Arun District Council
Arun Civic Centre
Maltravers Road
Littlehampton
West Sussex BN17 5LF
Planning & Building Control General Enquiries
Tel: (01903) 737756 Fax: (01903) 730442
Dx: 57406 Littlehampton
Minicom: 01903 732765
e-mail: planning@arun.gov.uk
website: www.arun.gov.uk/planning

Application No: FG/114/21/HH
Site Address: 23 South Drive Ferring BN12 5QU
Description of works: Extensions and internal and external remodelling of existing dwelling to create a 4no. bedroom dwelling with double garage including single storey rear extension, replacement and reformation of roof to create second floor accommodation with rear balcony, associated landscaping.

Thank you for your internet representation made on 31st July 2021 which has been recorded as an objection with the comments as follows:

Street Scene Elevations -
Existing & Proposed

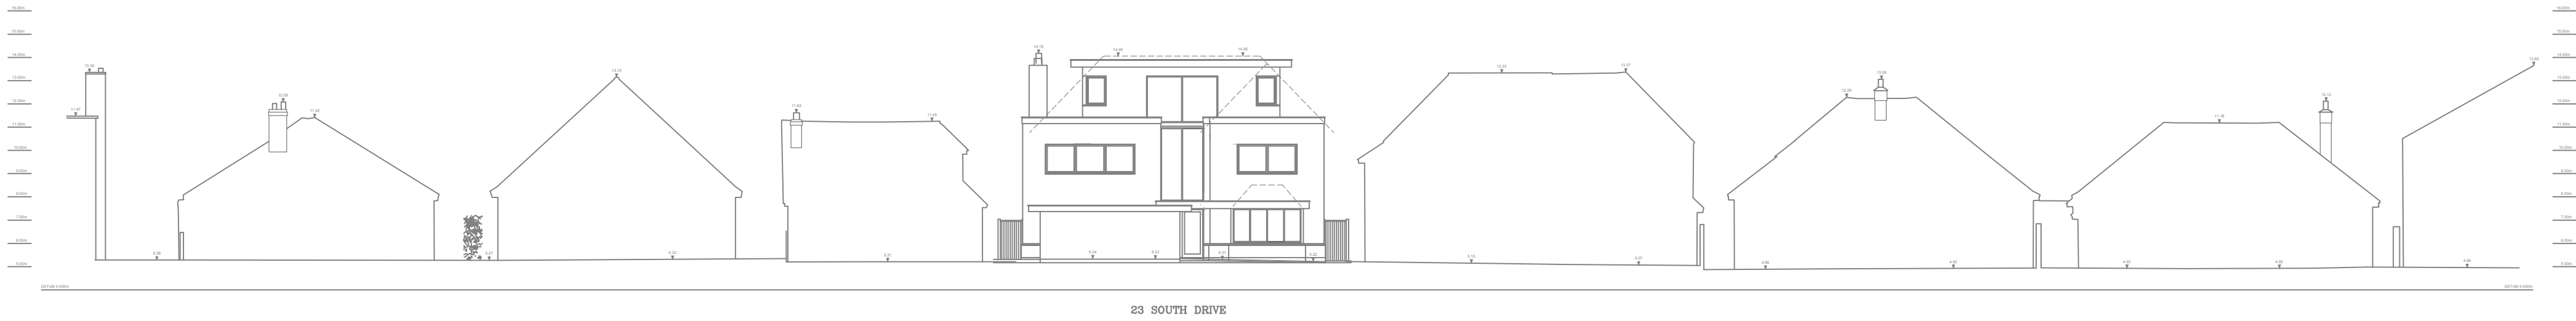
This proposed extended dwelling will be totally out of keeping with the other properties in this area of South Ferring, which is in an Area of Special Character. It is already a large house and changing it to a 3 storey building will dwarf the properties of the neighbours and destroy the ambience of Pattersons Walk.
